Level I Site Plan Application
Towle Single Family
CBL: 373-A-016001
Project ID: 2016-01988
Project Address: 1643 Washington Avenue

We received your review comments for the above referenced site plan.

TOWLE RESIDENCE
GARAGE PLAN
WASHINGTON AVENUE
PORTLAND, MAINE

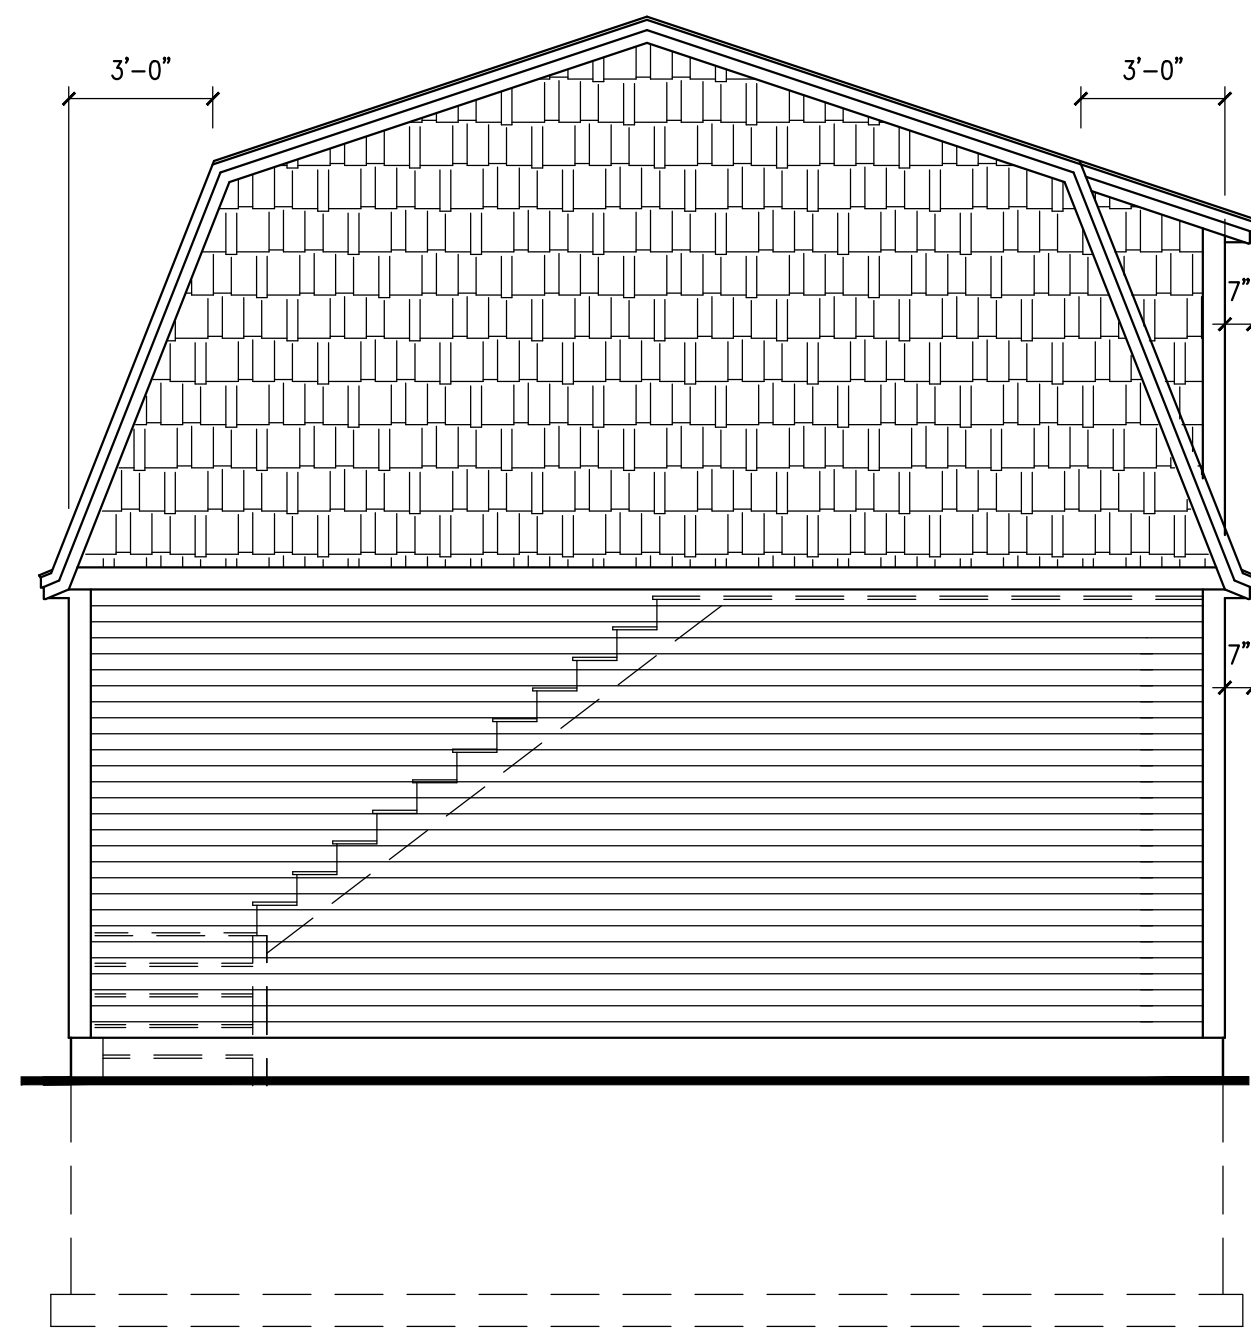
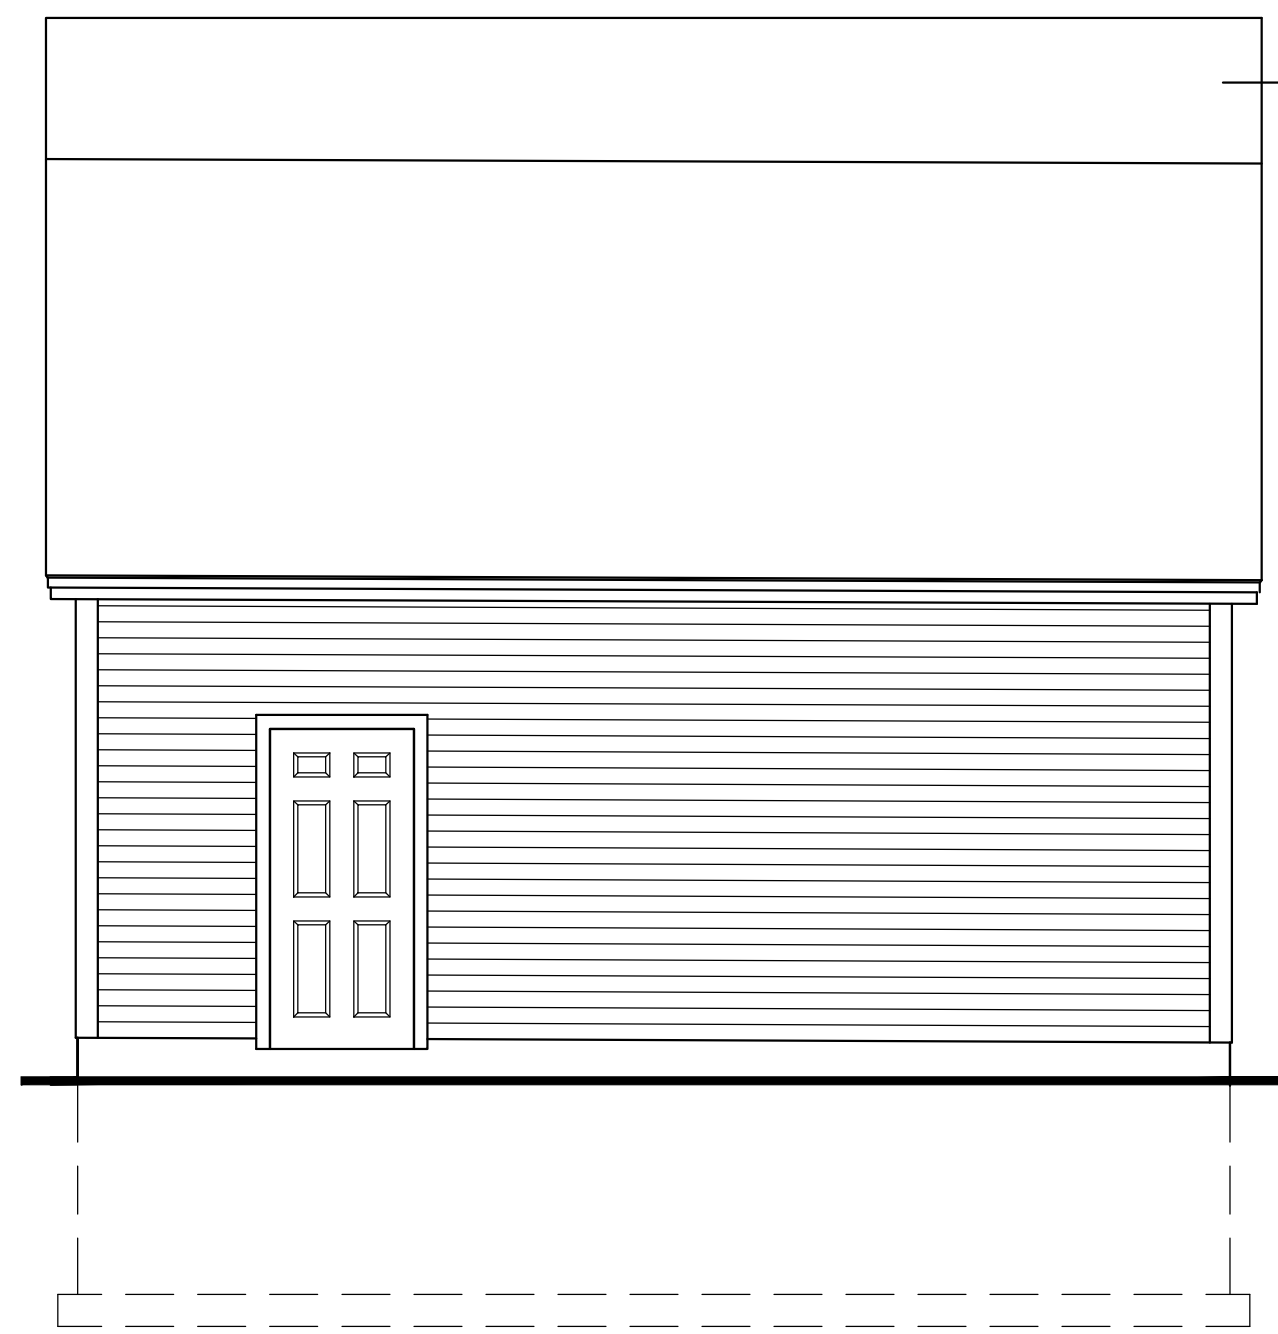
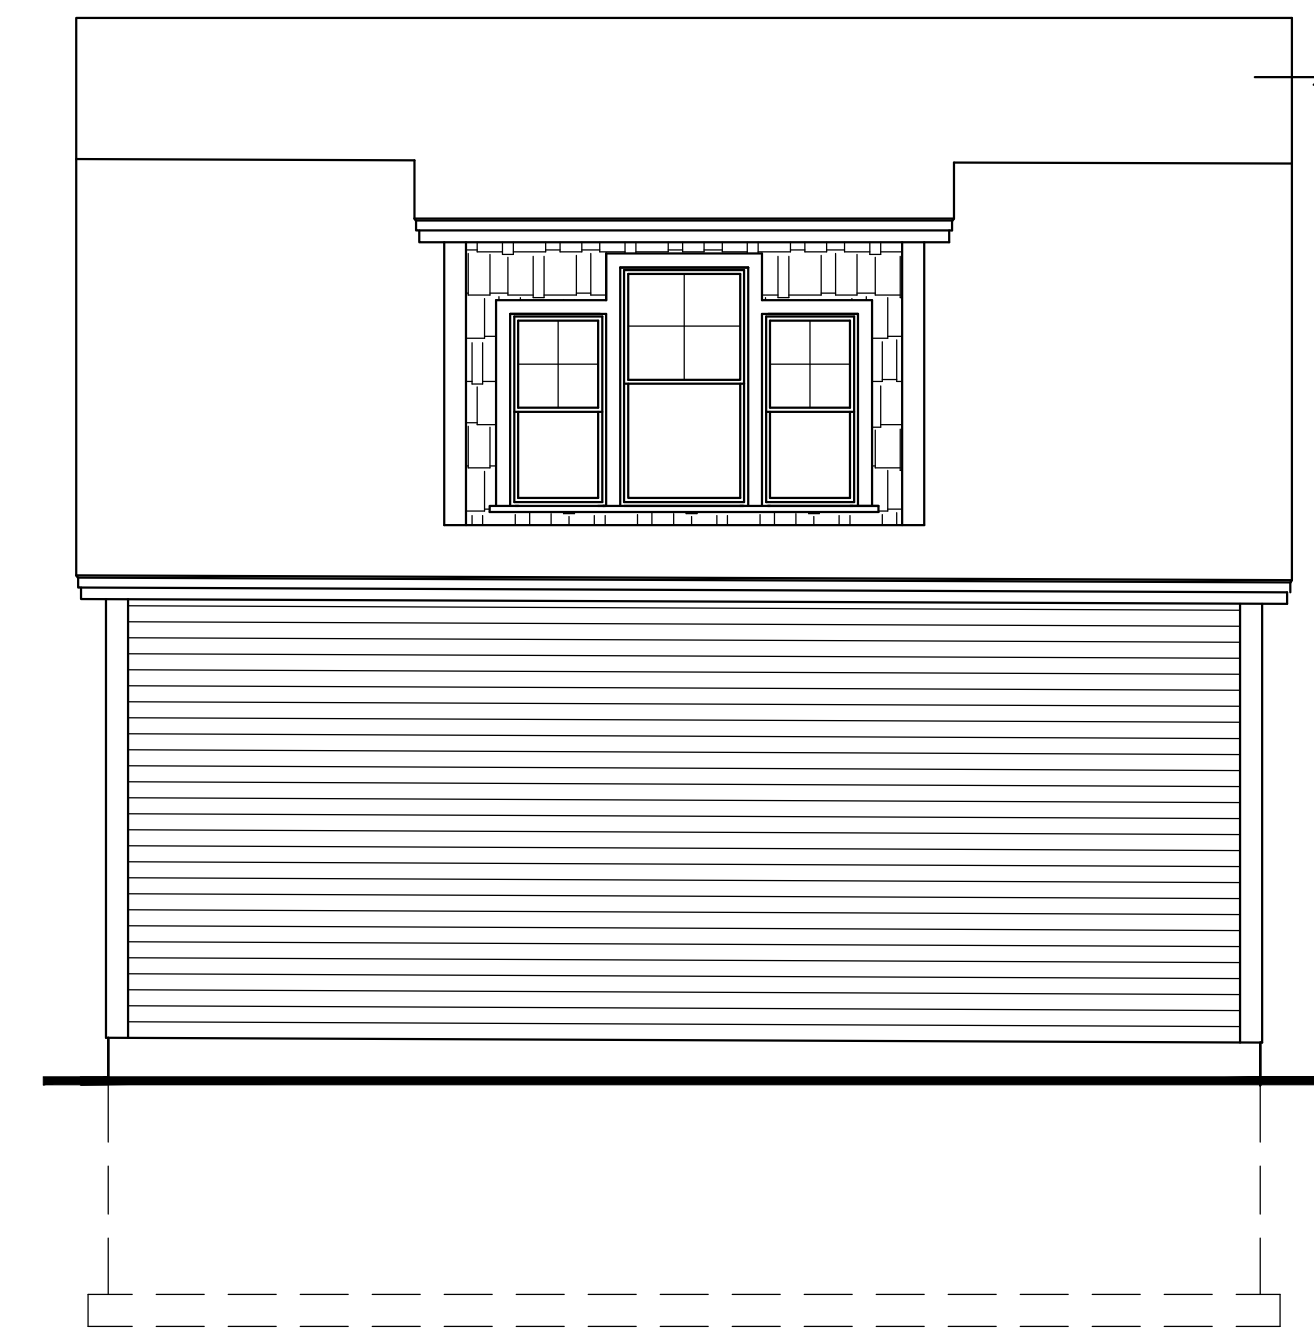
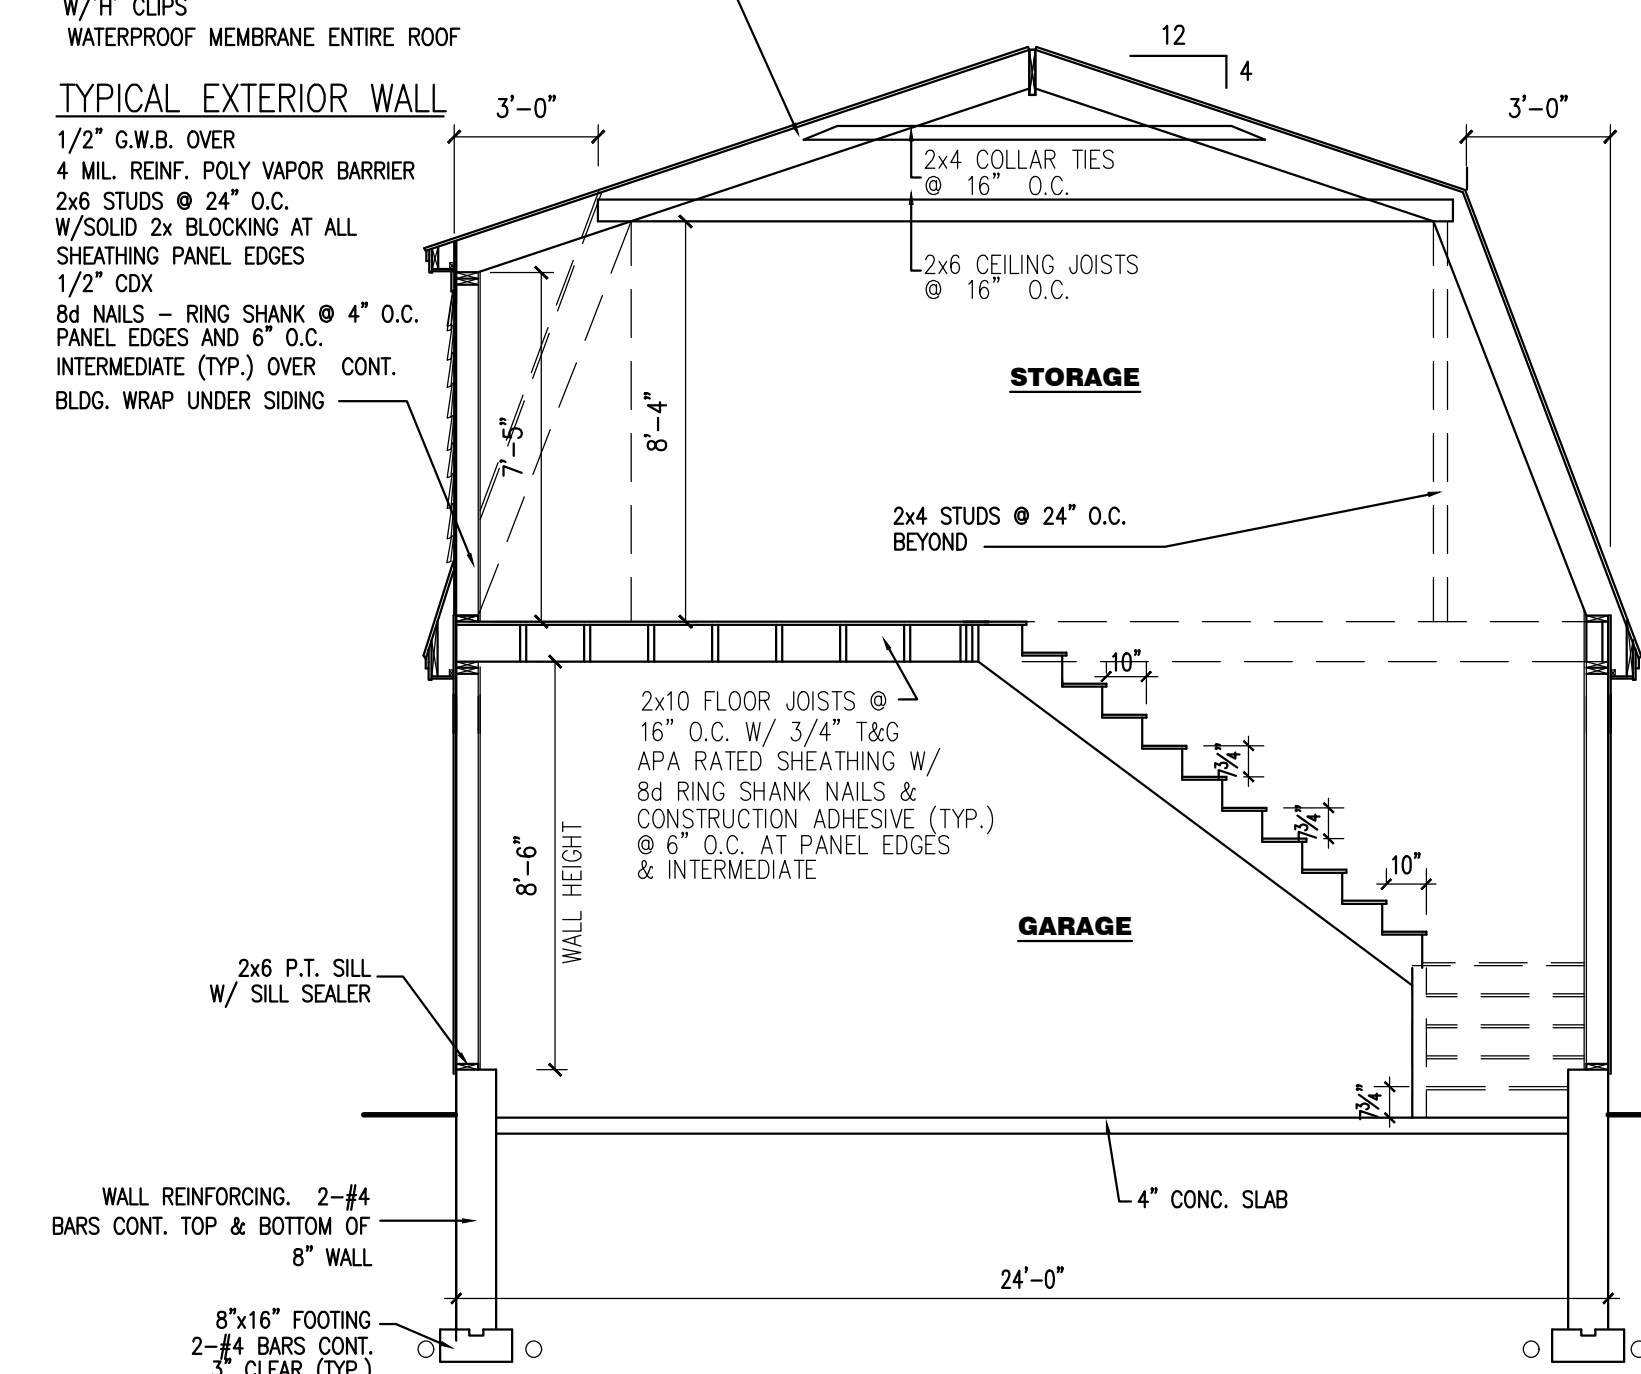
- *Zoning Specialist Chris Stacey has reviewed the project for zoning compliance and identified one issue regarding the proposed detached garage. In this zone, a detached structure is limited to 18 feet in height. The height of a gambrel structure is defined as "the vertical measurement from grade to a level two-thirds the distance from the level of the eaves to the highest point of the gambrel roof." Based on the submitted plans, it appears that the height of the garage is about 19.5', which would exceed the height limitation. The plans should be revised so that the garage meets this limitation. If you have questions about this, please contact Chris directly at 207-874-8695 or cstacey@portlandmaine.gov." The updated build plans have been attached.*
